Consultation Response from KC, Conservation and Design		
2021/90304 off, Low Westwood Lane, Wellhouse, Golcar, Huddersfield, HD7 4EW		
Erection of 7 dwellings, car parking and associated works (within a Conservation Area)		
Date Responded: 29.3.21	Responding Officer: Sue Oakley	Responding Ref:
<p>The brick arches on Low Westwood Lane in Wellhouse are unlisted structures within the Linthwaite Conservation Area and are located adjacent to a group of coal drops. Historic maps and photograph show a former goods shed / warehouse on the site and the arches appear to be the remains of this structure. They have some historic interest as an interesting remnant of railway architecture and industrial history within Linthwaite, although in its present condition the site makes a slight negative contribution to the character of the conservation area.</p> <p>The arches are situated on a prominent hillside directly in front of the main railway line running through the Colne Valley, and are visible from many aspects including from the opposite hillside and along Manchester Road. The steep hillside behind is semi-rural, with scattered terraces of C19 cottages and other dwellings amongst fields which

Front Elevation
1 : 100

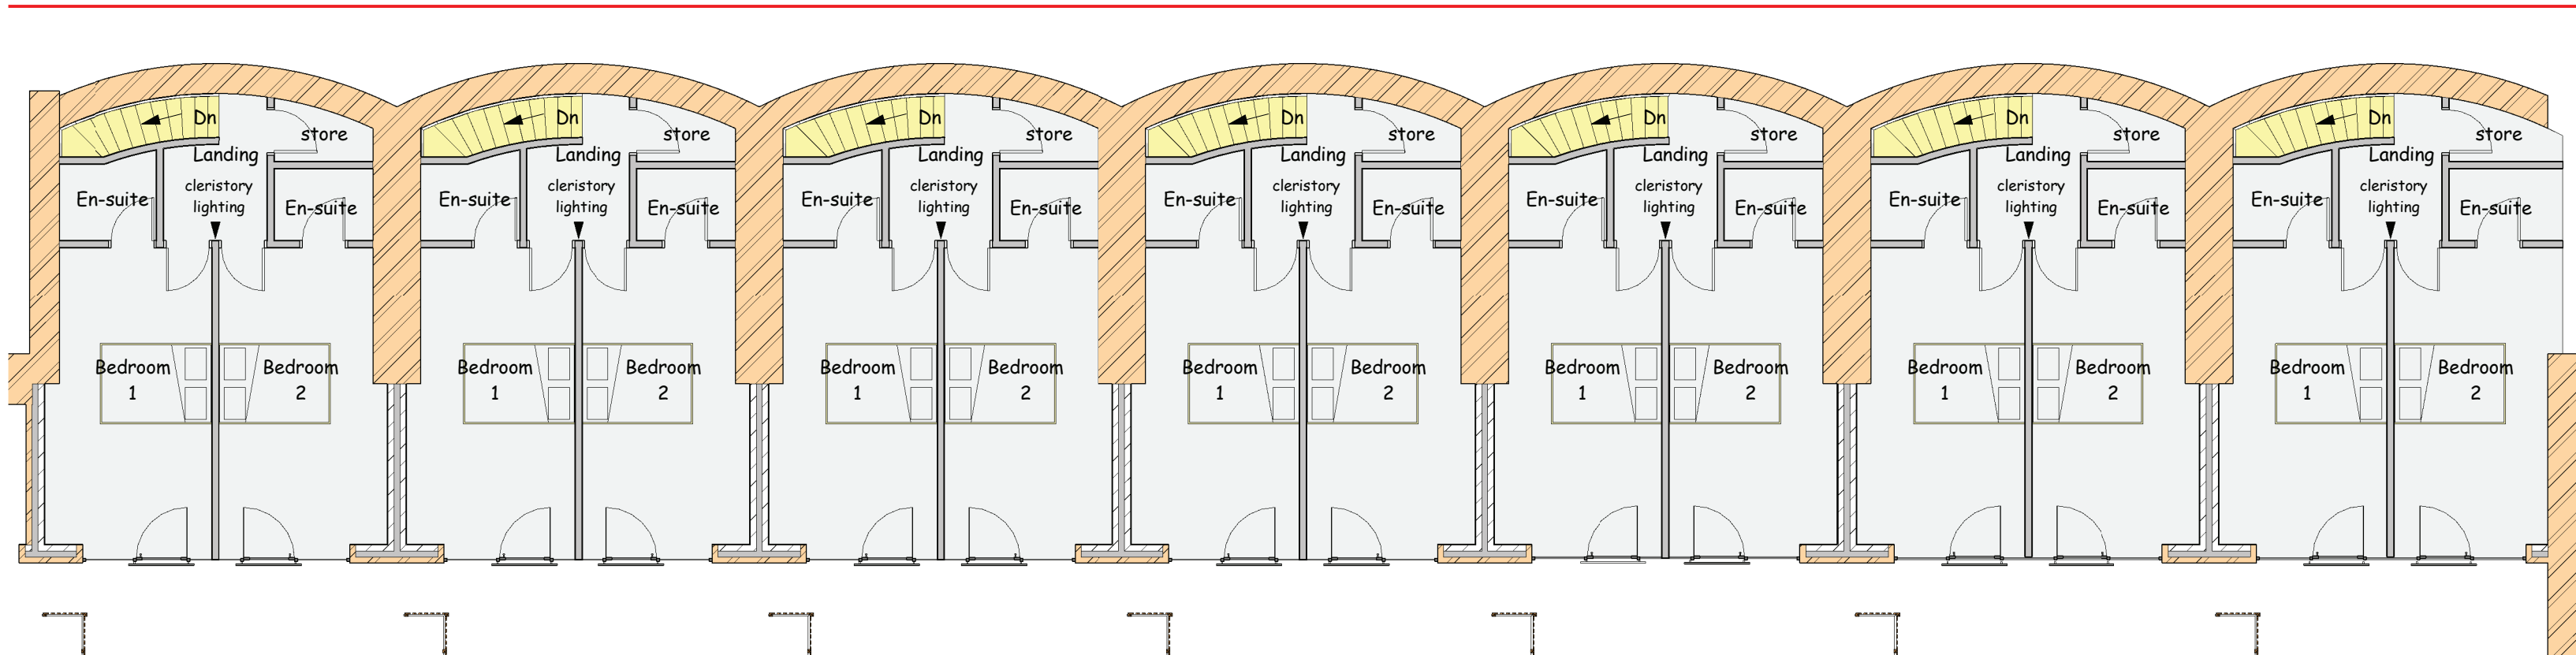
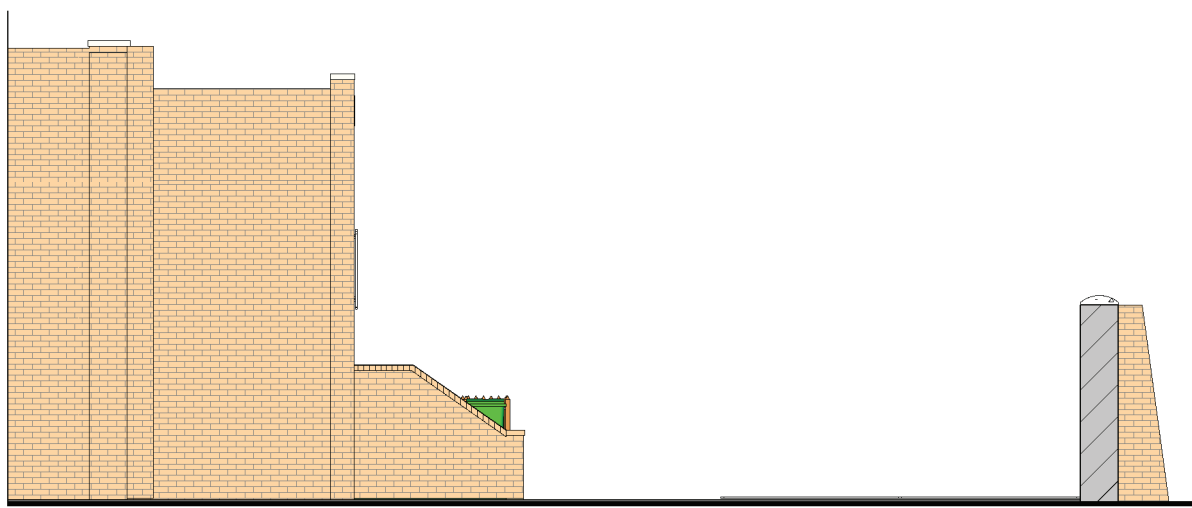
Paragraph 196 of the NPPF requires public benefits to be demonstrated to outweigh this harm. The public benefits of bringing a derelict site into use goes some way towards justifying development on this site but the design and access statement does not demonstrate that alternative, less harmful, options have been considered, which retain an unobstructed view of the arches without the use of an expanse of glazing.
